APPLICATION FOR A NON MATERIAL AMENDMENT UNDER SECTION 96A OF THE TOWN AND COUNTRY PLANNING ACT (1990) ACT TO REF. 75111/APP/2022/1007 WITH REGARDS TO:

- **ENERGY CENTRE 2**
- **ENERGY CENTRE 3**
- **VISITOR RECEPETION CENTRE 1**

LAND AT BULLS BRIDGE INDUSTRIAL ESTATE, NORTH HYDE GARDENS, HAYES, UB3 4QQ

7 03050 - Roof
1 : 200

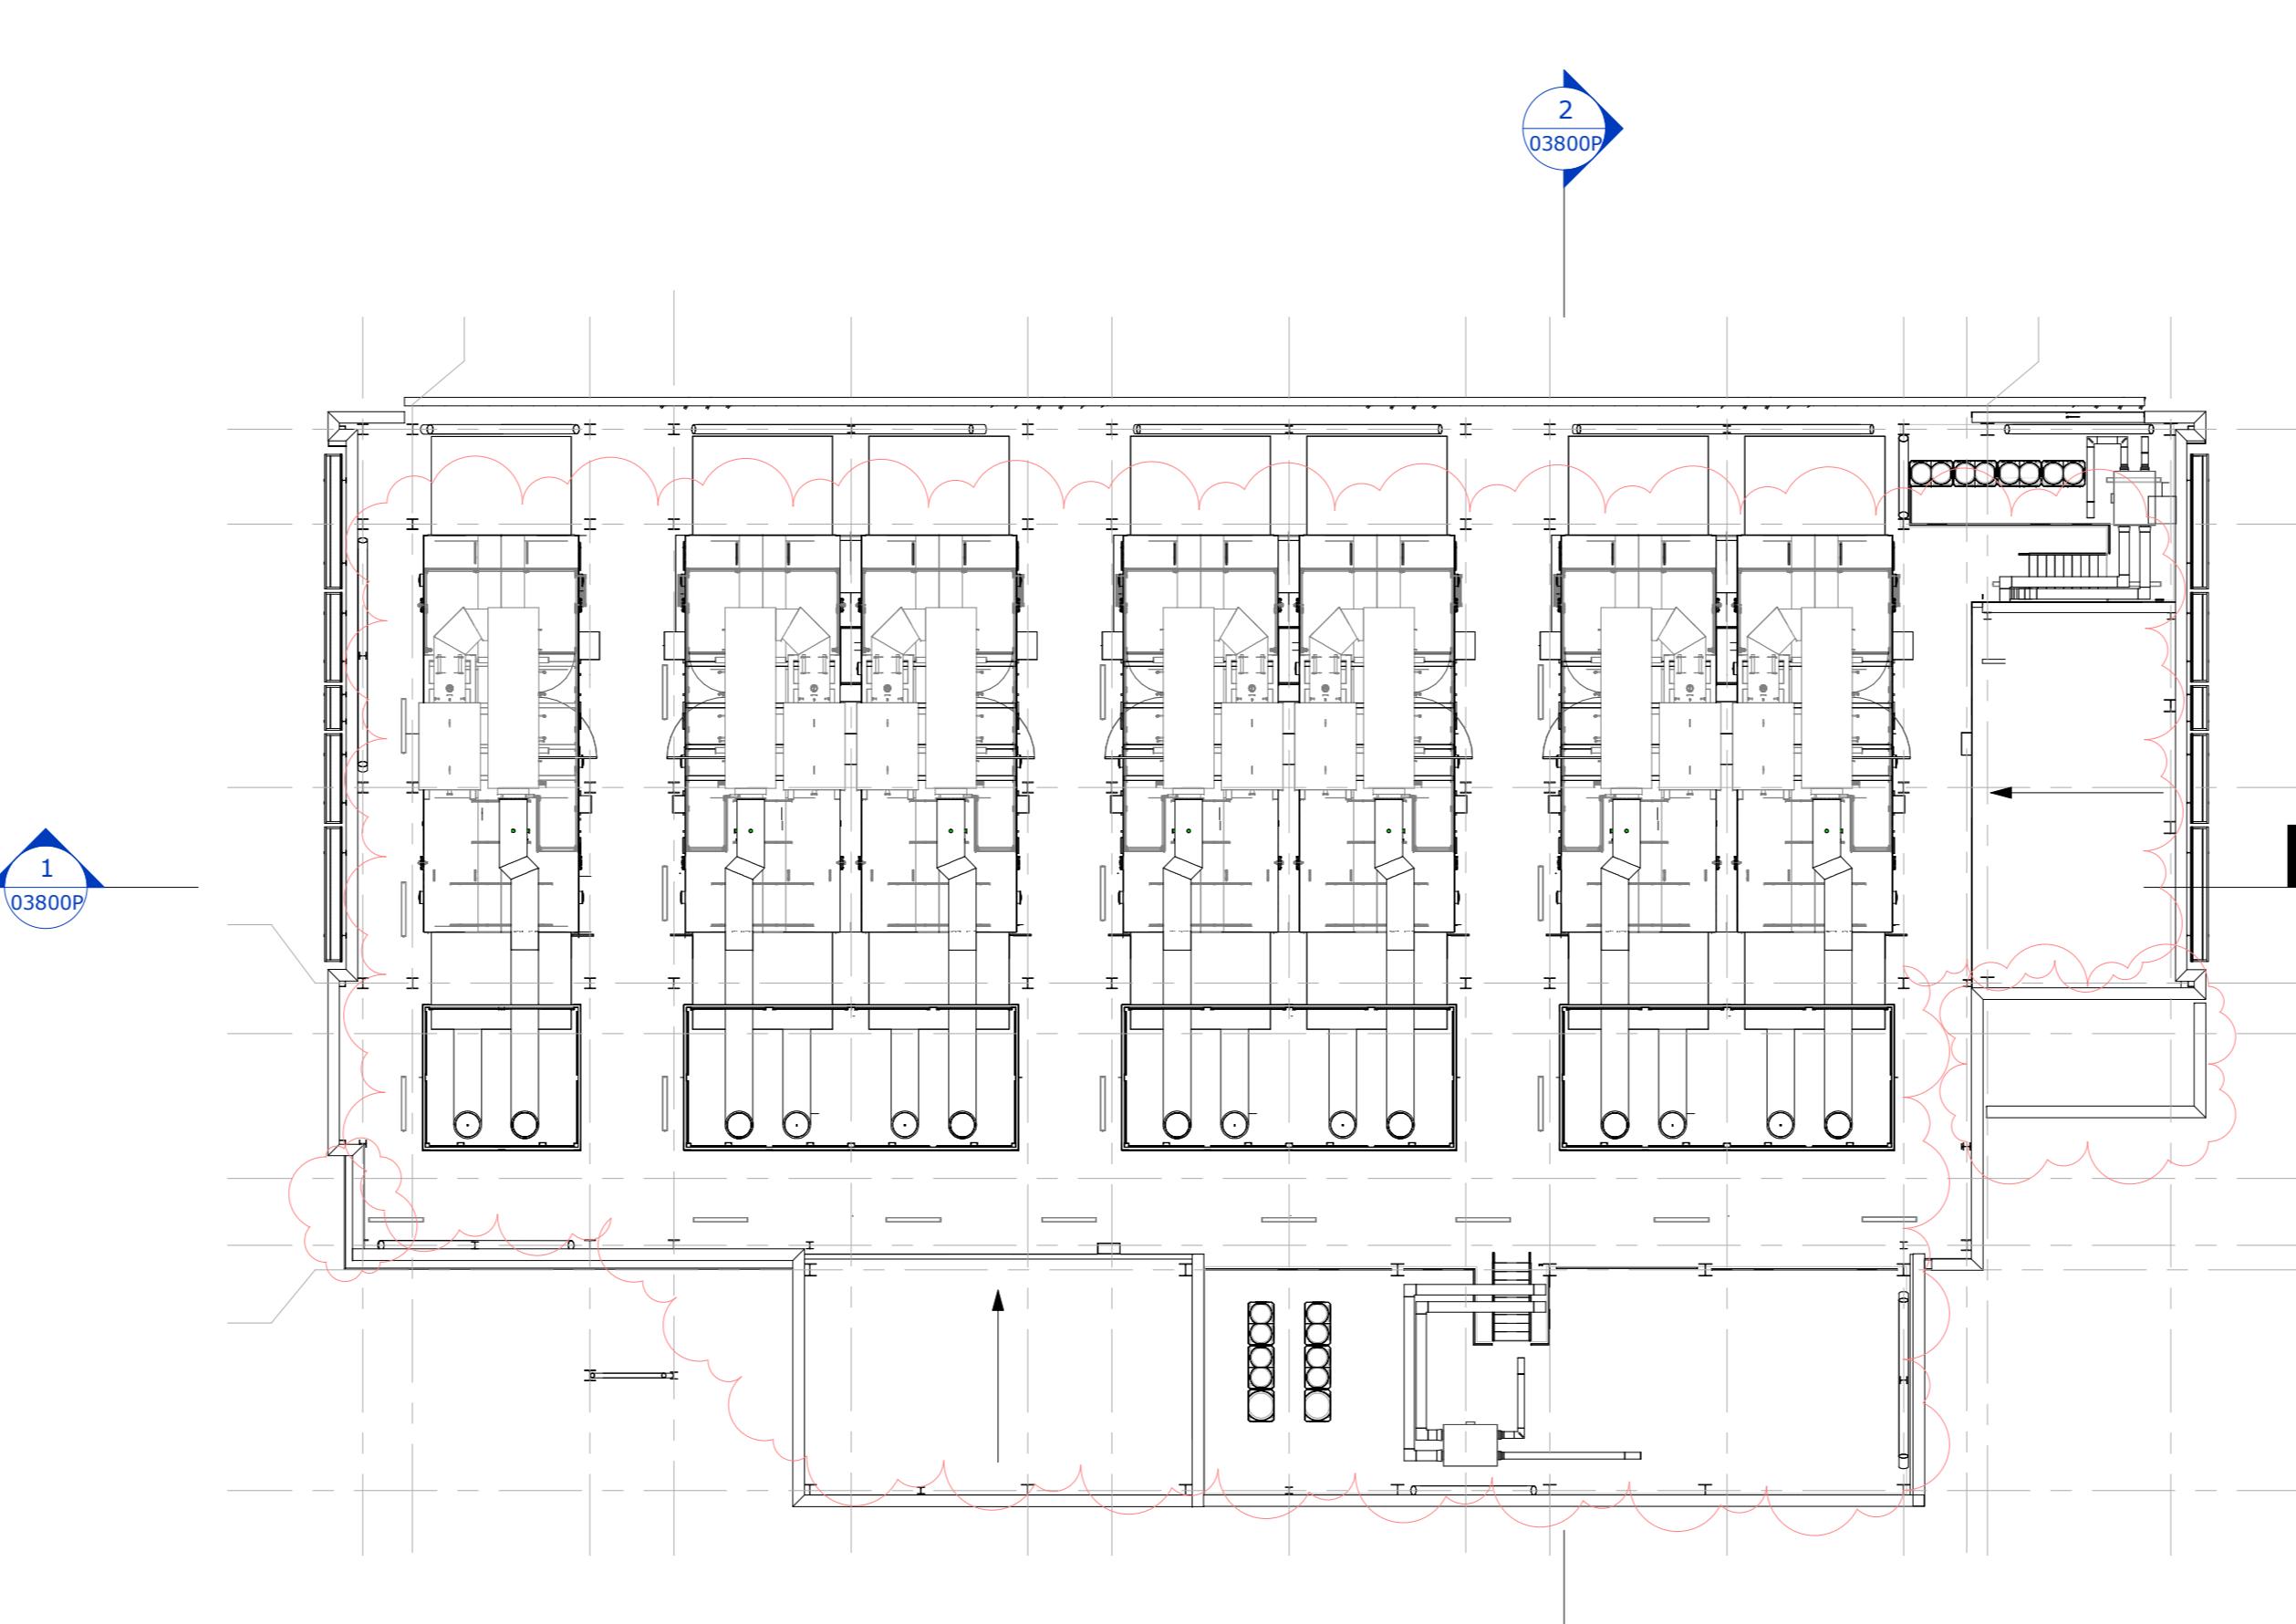
- Installation of an additional staircase at the southeastern corner of the building. This will be clad in the same materials as the wider building;
- Modest refinement of the footprint of Energy Centre 2 along its western and southern boundary. As shown on the plans submitted, these changes are modest in the extreme and could reasonably be considered to be de minimis;

- To facilitate plant replacement, there is a requirement for the replacement of the brickwork along the northern elevation of Energy Centre 2 with louvres and the replacement of landscaping with planters to facilitate access;

- Reconfiguration of the green wall arrangement along the building's southern and western elevations. Importantly, the quantum of green walling (and the urban greening factor that is achieved) remains unchanged; and

- Reconfiguration of the building's internal arrangement which will mean that the heat rejection stacks will no longer be visible.
